Consultation Response from KC, Highways Development Management
2020/91919 The Co Operative Food, 19, Northgate, Almondbury, Huddersfield, HD5 8RX
Demolition of existing supermarket and erection of block of 6 flats with associated parking (within a Conservation Area)
Date Responded: 13/10/21 Responding Officer: J Turner Responding Ref: K6-15SE/6

SCALE: As indicated **DWG NO:** 3750-03

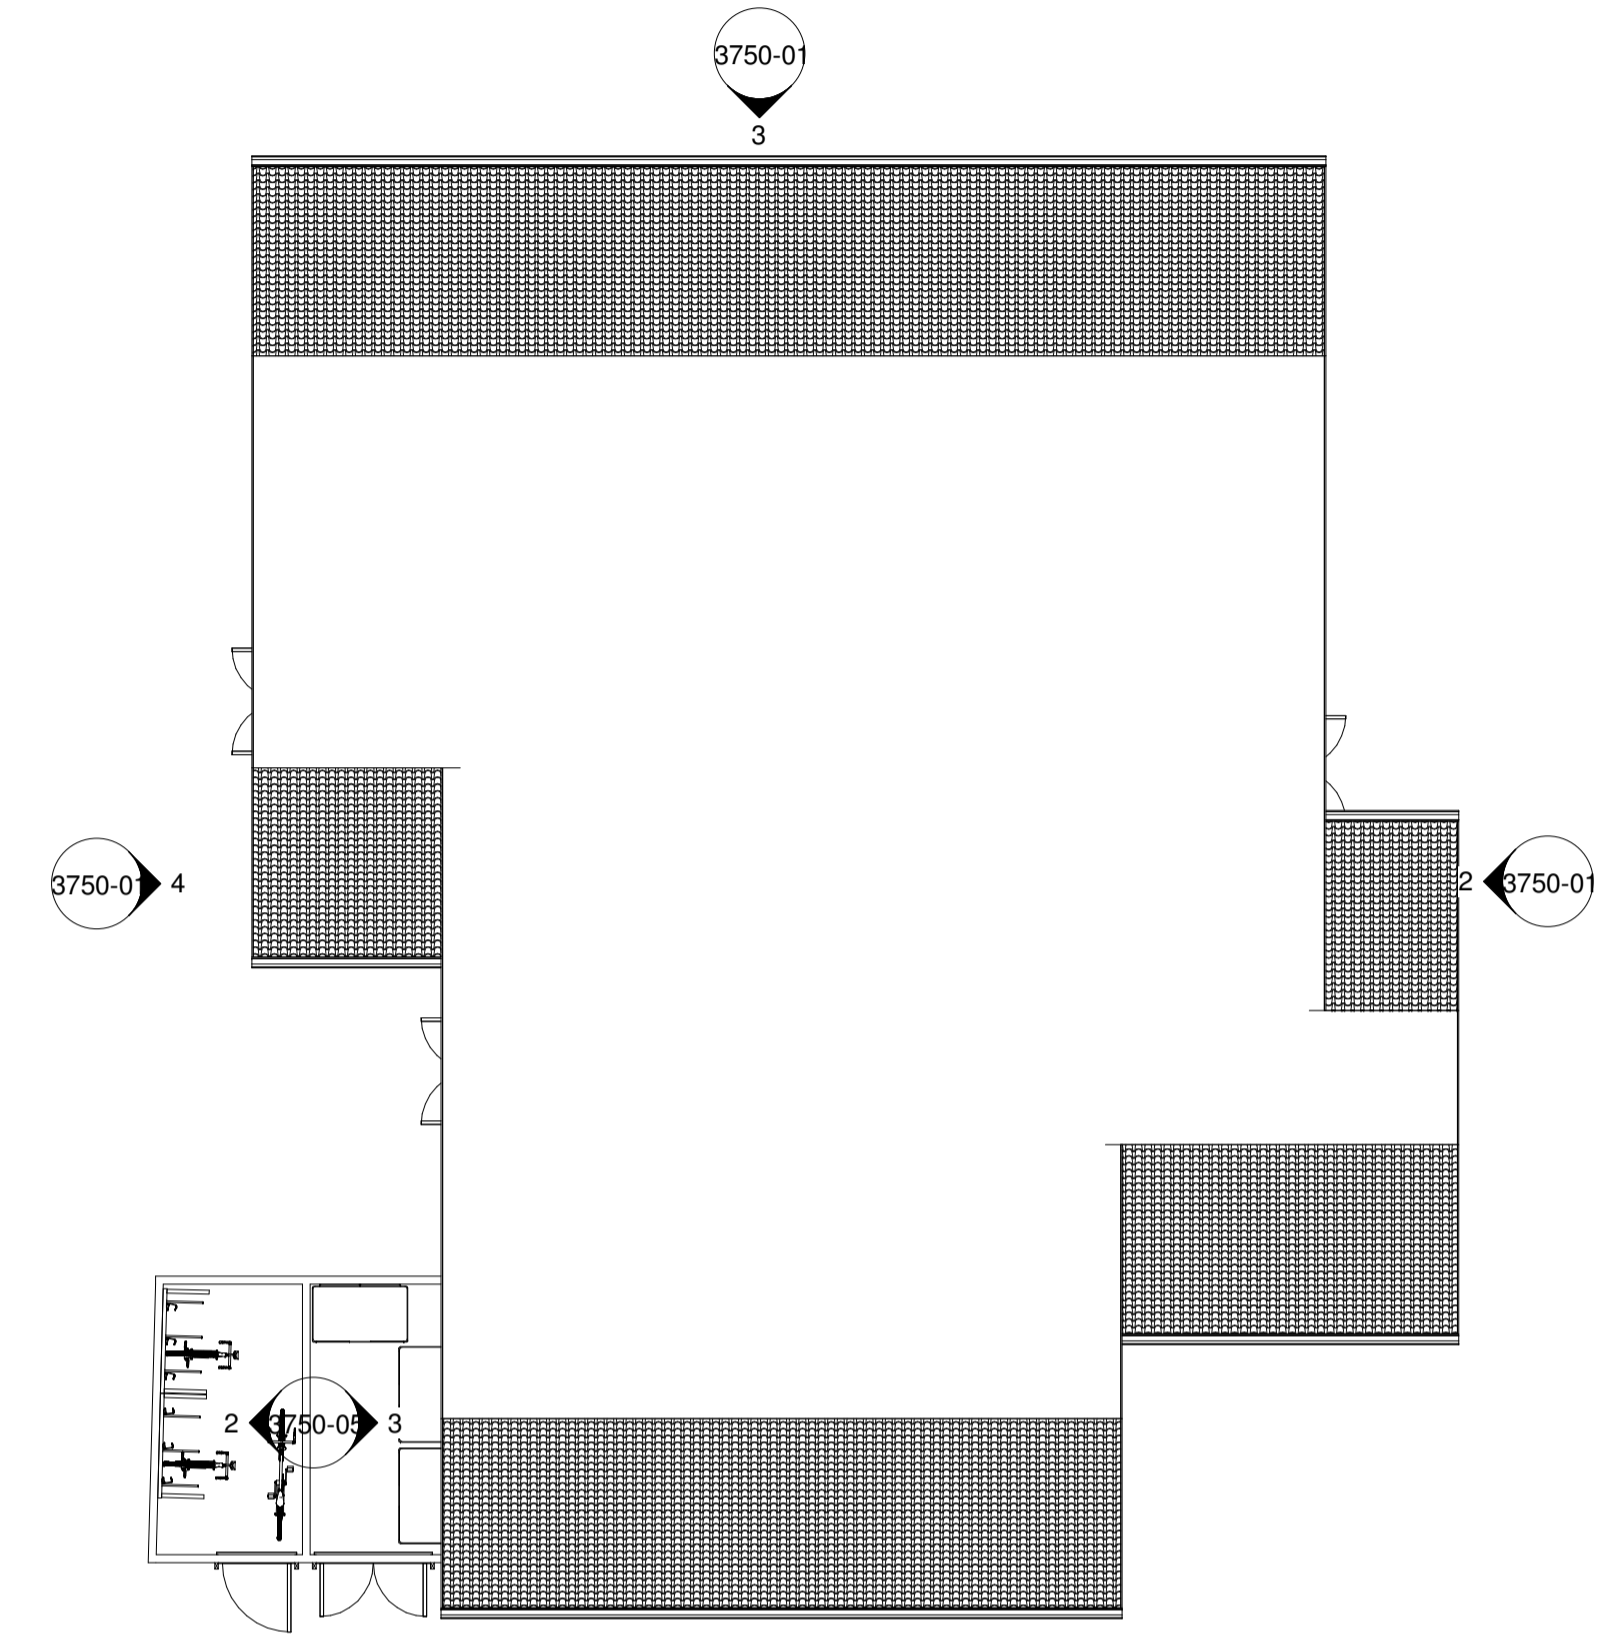
Bin and cycle storage plus a bin collection pad are satisfactorily demonstrated on drawing no. 3750-04.
